Ribble Valley
Borough Council

TREE WORK ASSESSMENT

TPO: 143 – 1996 Calderstones

APPLICATION NO: 3/2026/0553

Photos showing the encroachment over the boundary fence and over the roof of the property.

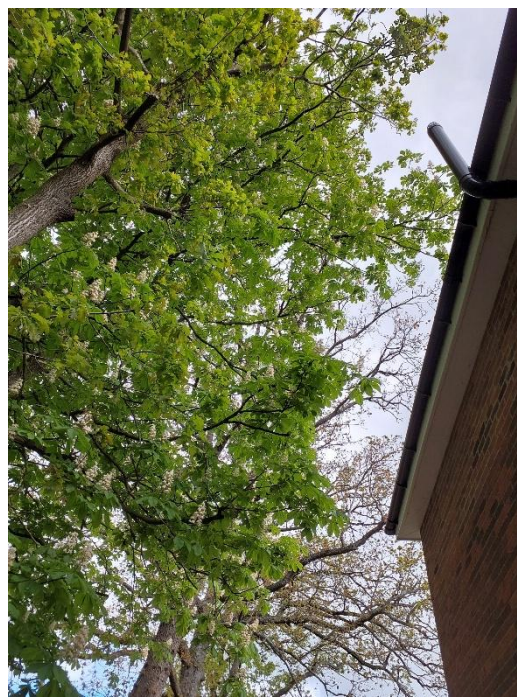
However, the Council have contacted the applicants consultant to minimise the amount to prune as the majority of the suppressed oaks crown is leaning over the neighbours garden and pruning back to the fence line would not conform to BS3998

Tree T003 "Horse chestnut (Aesculus hippocastanum)" _ Prune to clear building by 1.5m."

Tree T004 "Oak (Quercus sp.)" _ Prune to clear building by 1.5m.

They have agreed to a change to the description of works below which will enable the tree contractor to clear the house by 1.5m which will alleviate their issue and not affect the overall amenity value or health of the trees.
